From: Laura Gibbons <Laura.Gibbons@arun.gov.uk>
Sent: 27 July 2021 11:38
To: Planning.Responses <Planning.Responses@arun.gov.uk>
Cc: Michael Eastham <Michael.Eastham@arun.gov.uk>
Subject: RE: Planning Consultation on: A/110/21/PL

Engineers Comments Regarding Surface Water Drainage

Application No: A/110/21/PL
Registered: 3rd June 2021
Site Address: BMW House Chandlers Garage Ltd Water Lane Angmering BN16 4EH
Grid Reference: 506925 104447
Description of Works: Erection of retirement apartment with 20 No. 1 Bed flats & 13 No.2 Bed flats with communal facilities & car parking, erection of a retail store with car parking & associated highway works. This application affect the character & appearance of the Angmering Conservation area, affects the setting of listed buildings and is in CIL Zone 2 (Zero Rated) as other development.

SO-2729-03-DE-0500 P01

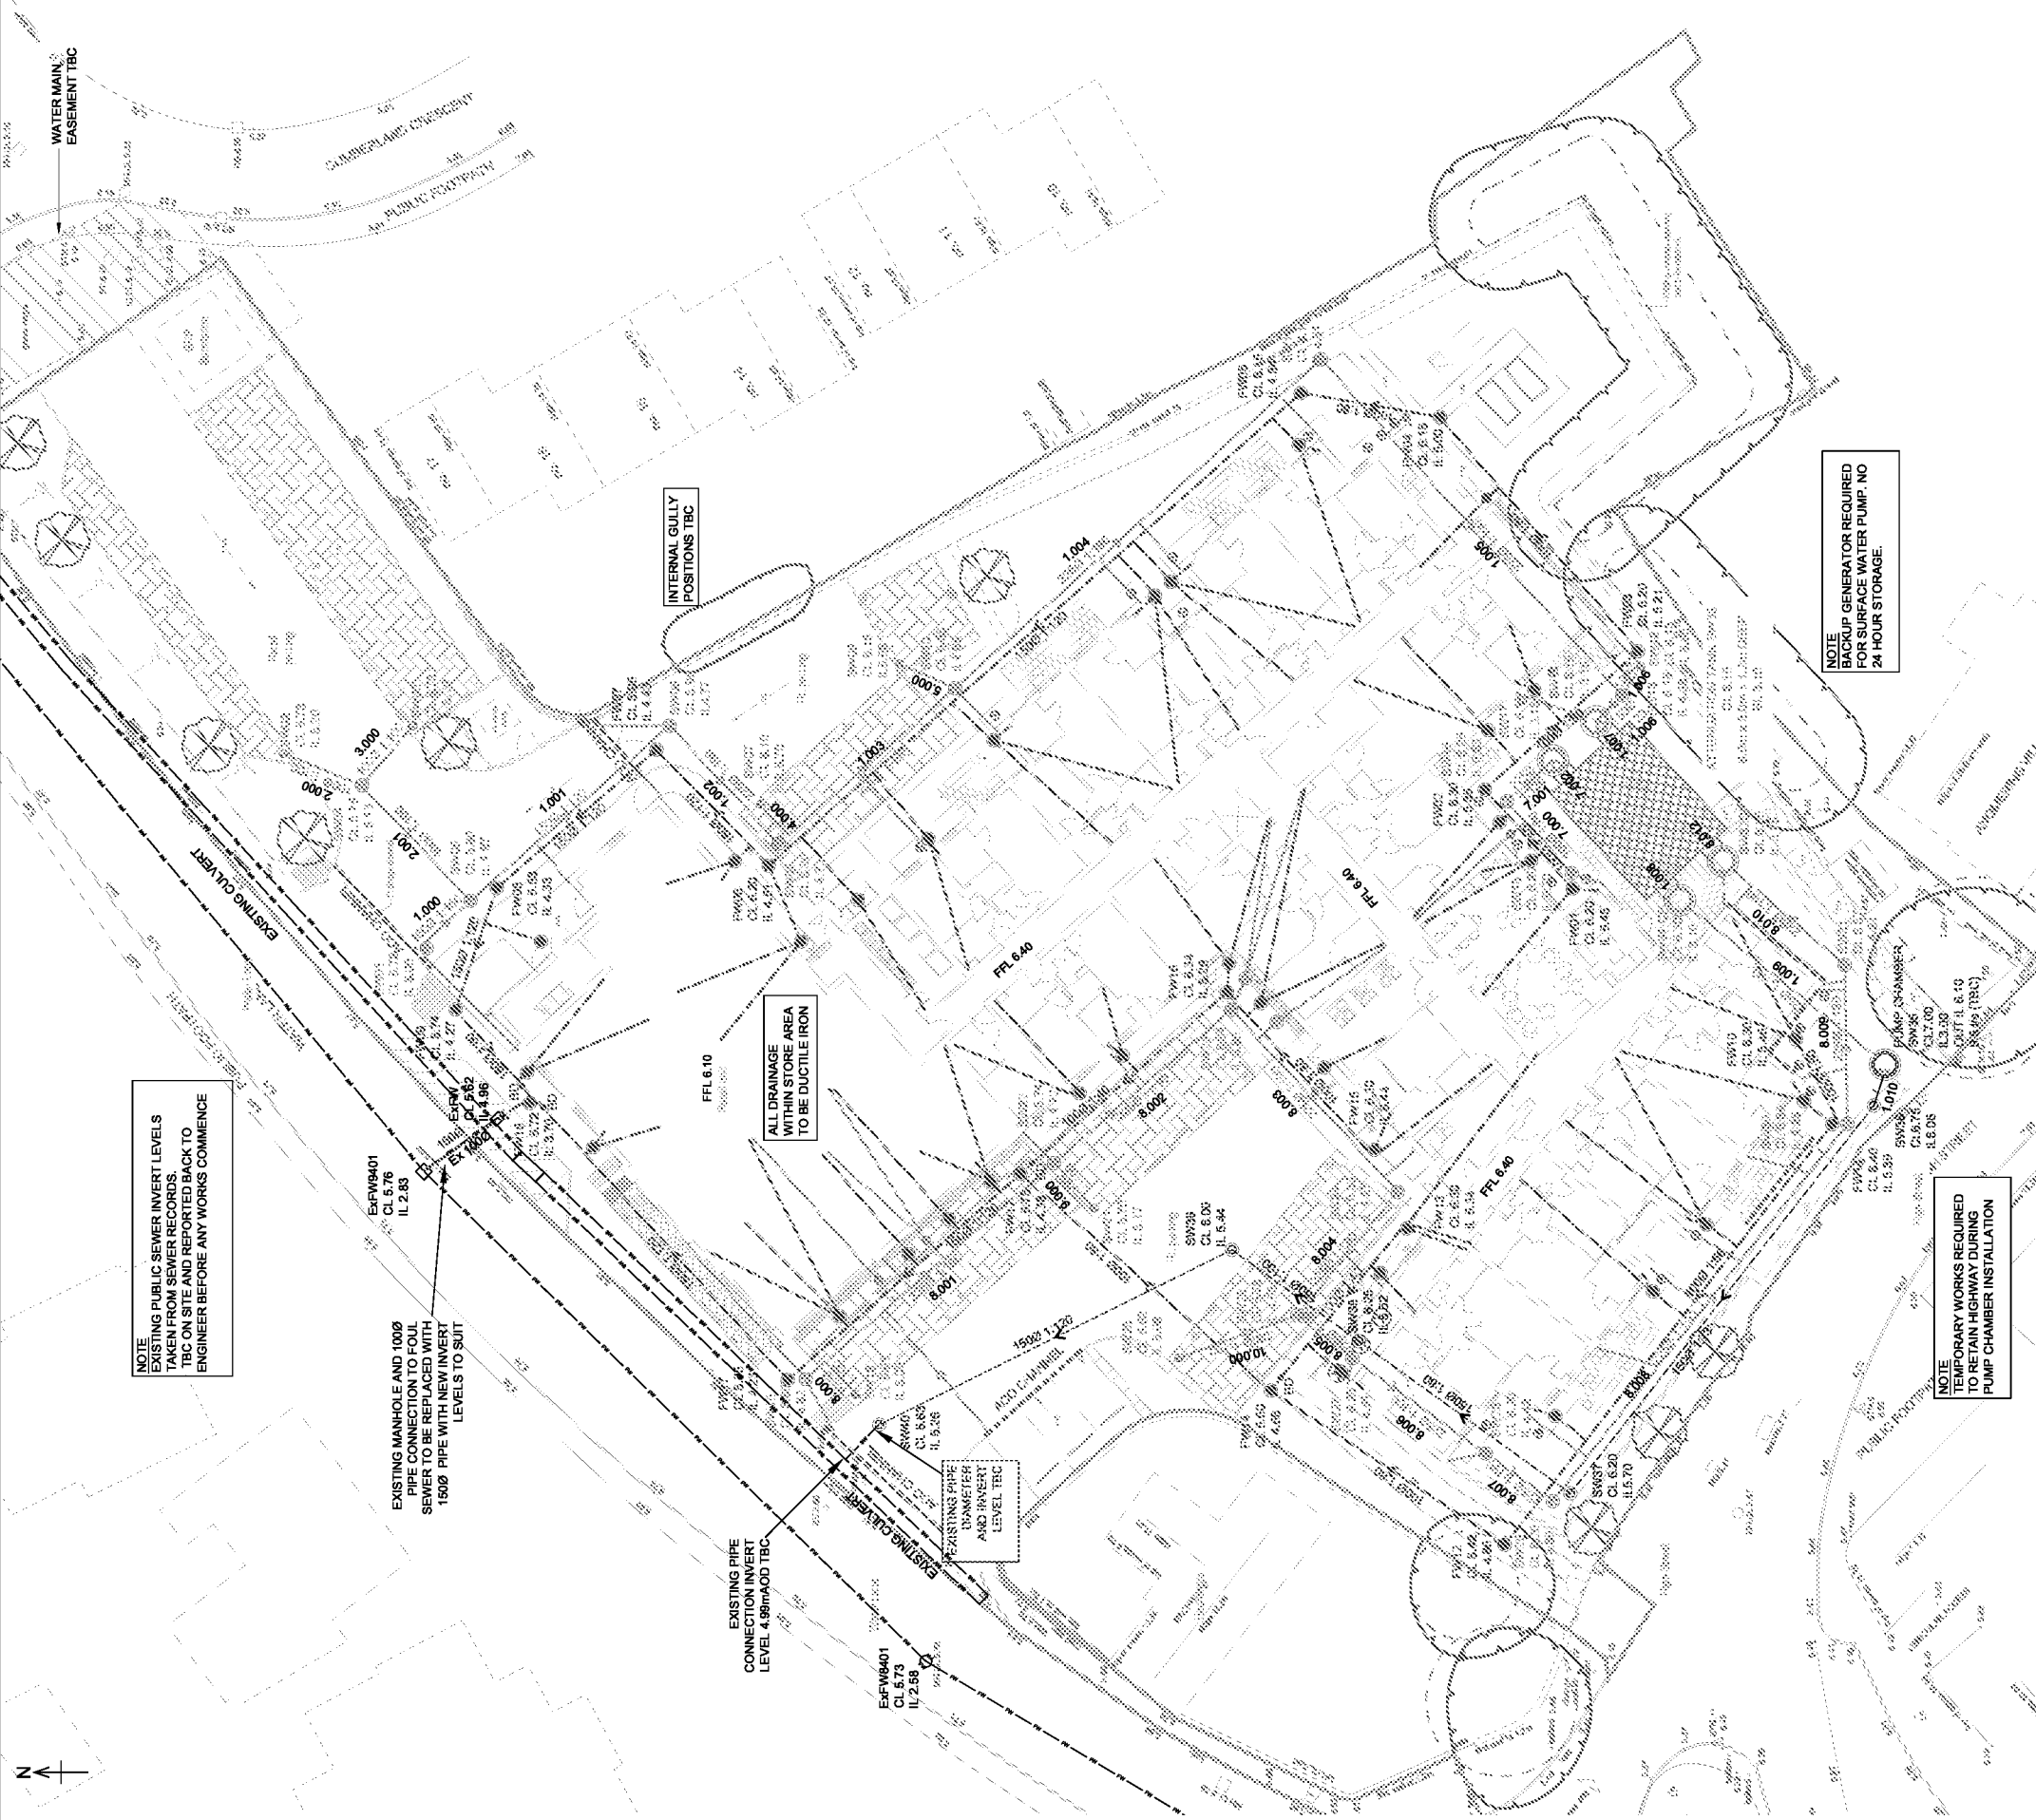
The surface water drainage strategy is proposed to use attenuation tanks and pump surface water at a discharge rate equivalent to 50% of the brownfield rate. Local policies are clear that where possible brownfield sites should discharge at greenfield QBar, or as close to this as possible, with a maximum discharge equivalent to 50% of brownfield rate. The applicant must demonstrate why they cannot discharge at greenfield QBar (based upon the positively drained area) and how close to this rate they can achieve.

Pumping is not supported, as per policy 3 of the adopted West Sussex Lead Local Flood Authority Policy for the management of surface water.

It is not clear how the proposals will deliver adequate treatment of water prior to discharge, or how the proposed SuDS will provide any amenity or biodiversity value. Surface water drainage calculations must use latest FEH rainfall data, apply appropriate urban creep allowances and appropriate Cv values.

Based on the above we wish to raise a HOLDING OBJECTION to this application. It has not been evidenced that the proposed layout can be adequately drained in accordance with policy requirements. Surface water drainage must be considered at the earliest opportunity and form part of the layout development process. Leaving drainage design until after a layout has been agreed will likely unduly prejudice drainage design and not allow for the hierarchy for sustainable drainage to be followed.

- Evidence to demonstrate the maximum storage available on site and the associated discharge rate. This is required to demonstrate that discharge will be restricted to as close to greenfield QBar as is achievable.

- A gravity surface water drainage system. Including revised compliant calculations and a revised surface water drainage layout.
- Details of pollution mitigation indices delivered through drainage proposals.
